# CITY OF ALBUQUERQUE

DZP.  
1003815

**Re: Office/Warehouse Development, 9550 San Mateo Blvd NE, Grading and Drainage Plan**

**Engineer's Stamp date 8-19-09 (B18/D016)**

Date:	No. Revision:	Date:	Job No.
06/30/11	1 REVISED NORTH SIDE GRADES	06/30/11	1666
Drawn By:	BJB		CG-101
Ckd By:	FCA		SH. OF

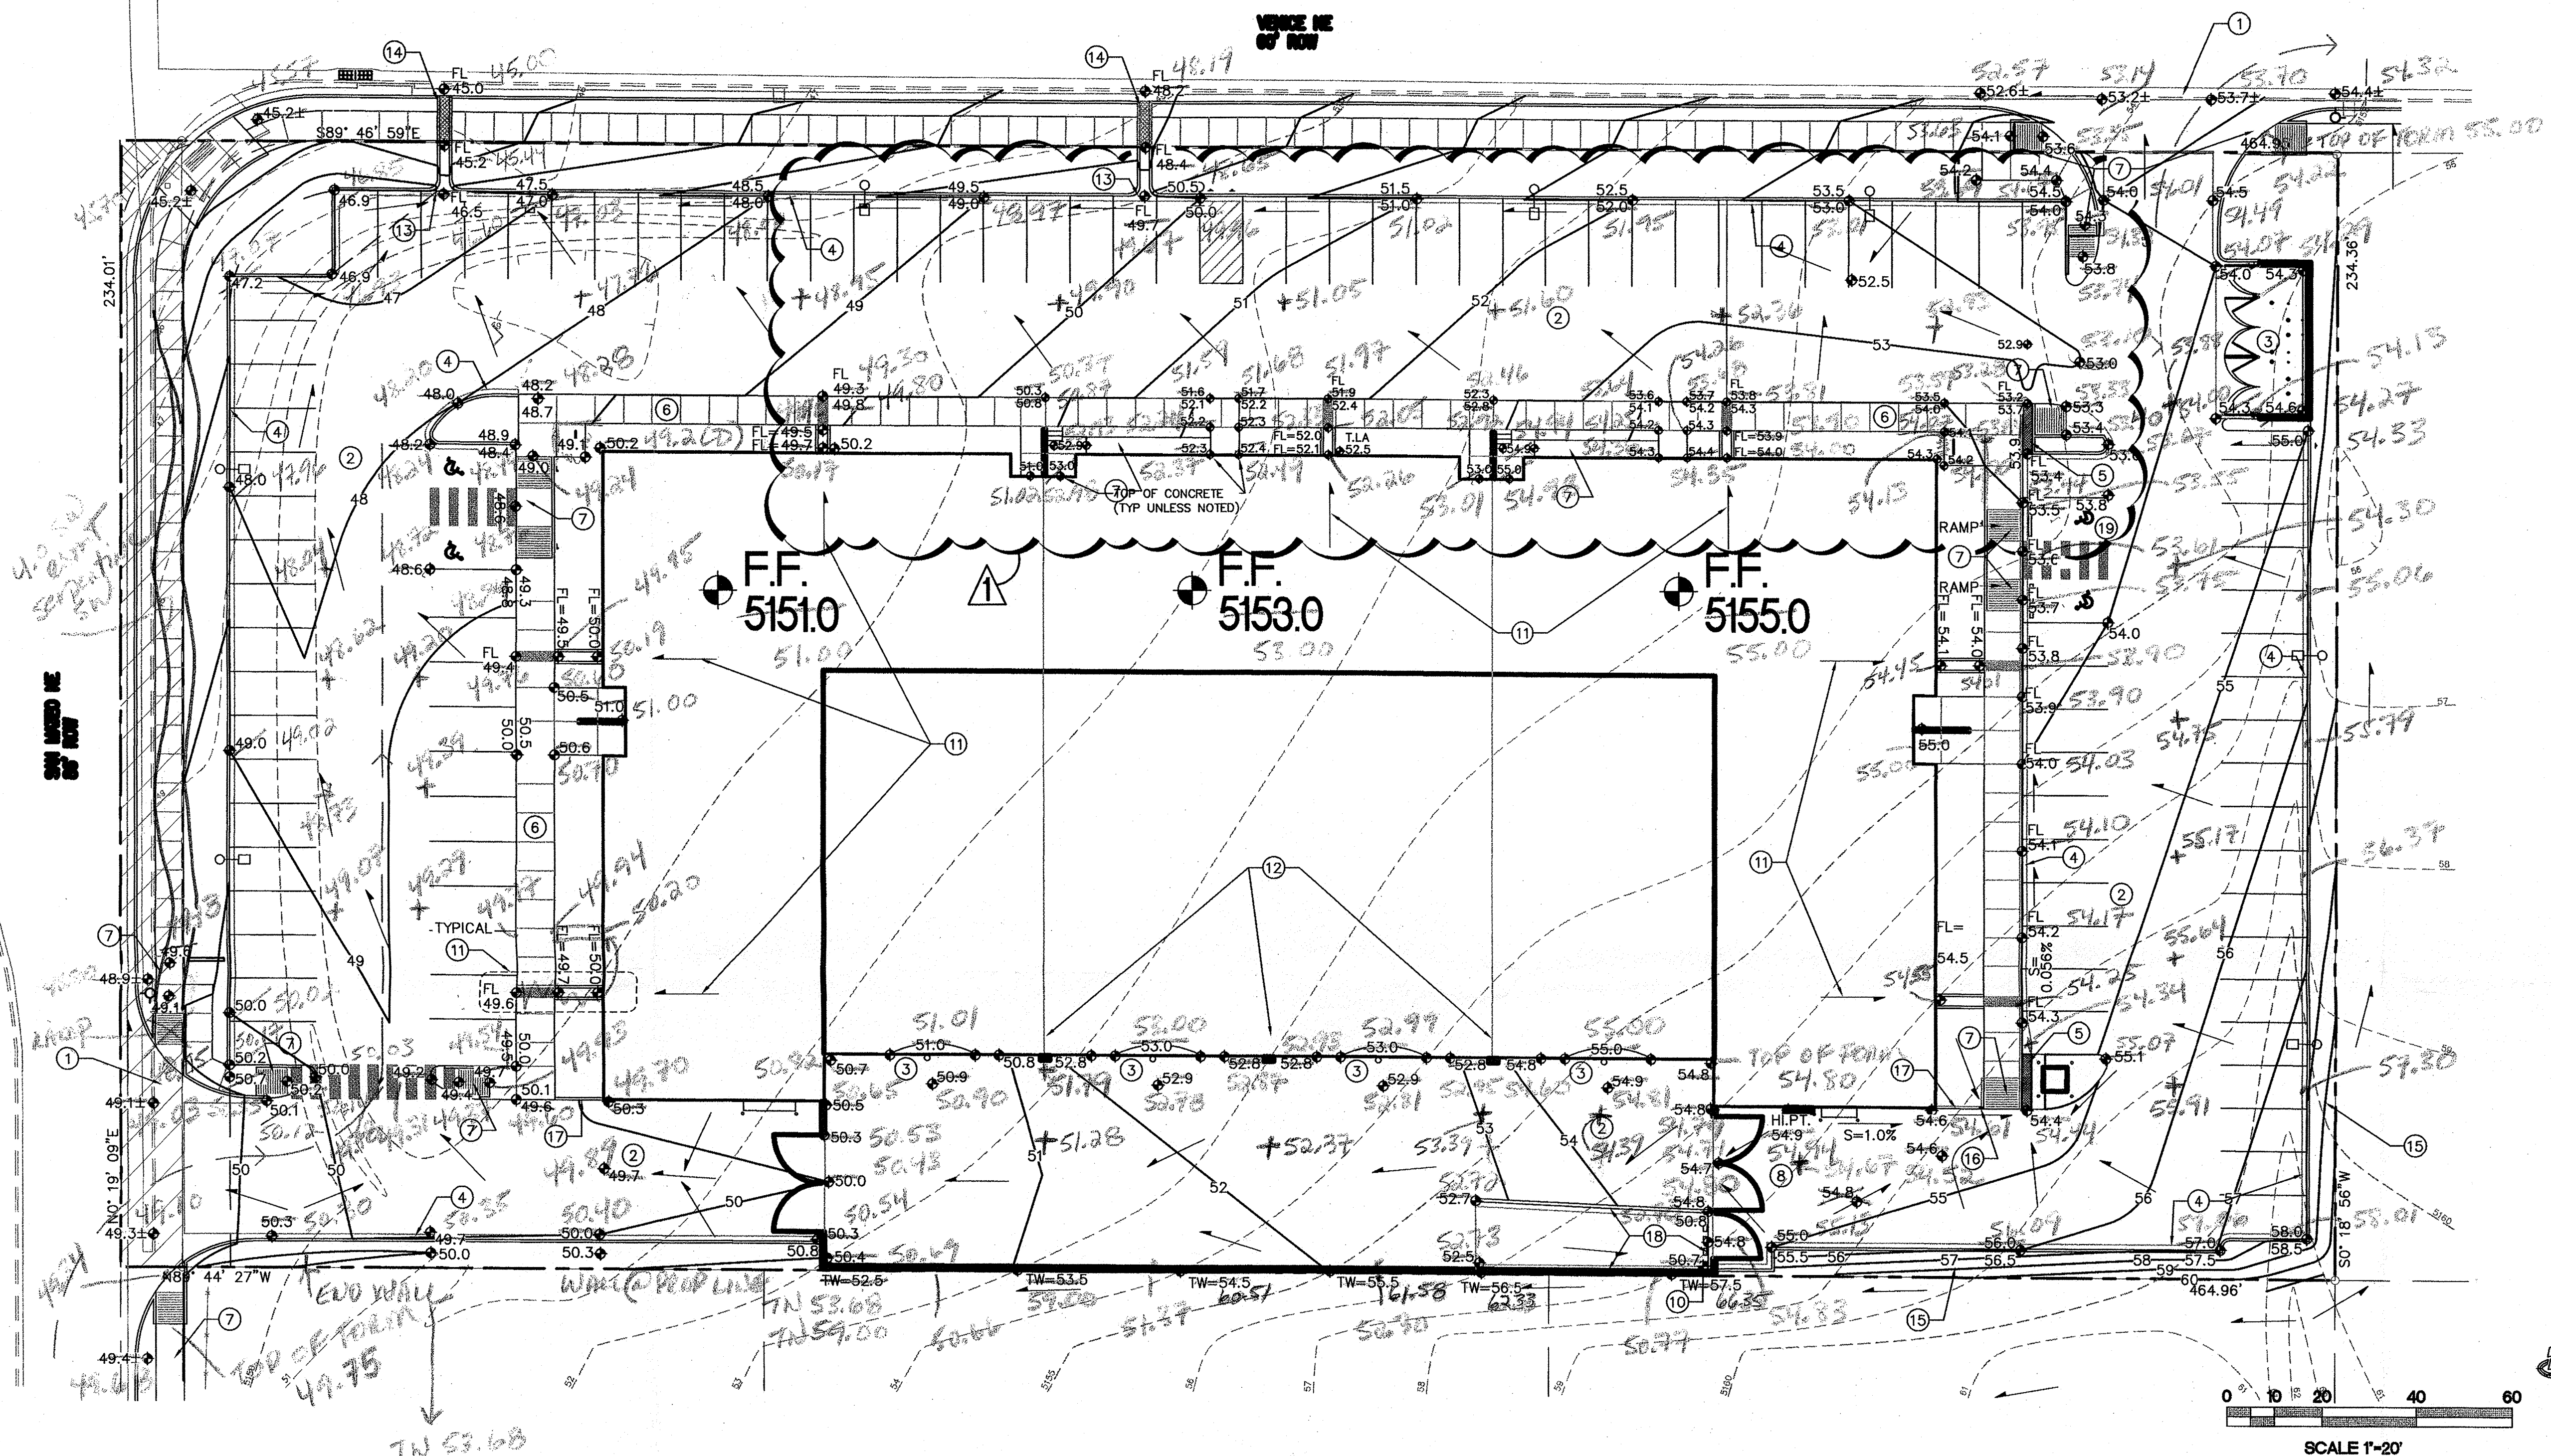
Include the TW elevation on the west end of the wall on the south side of the site on the Certification.
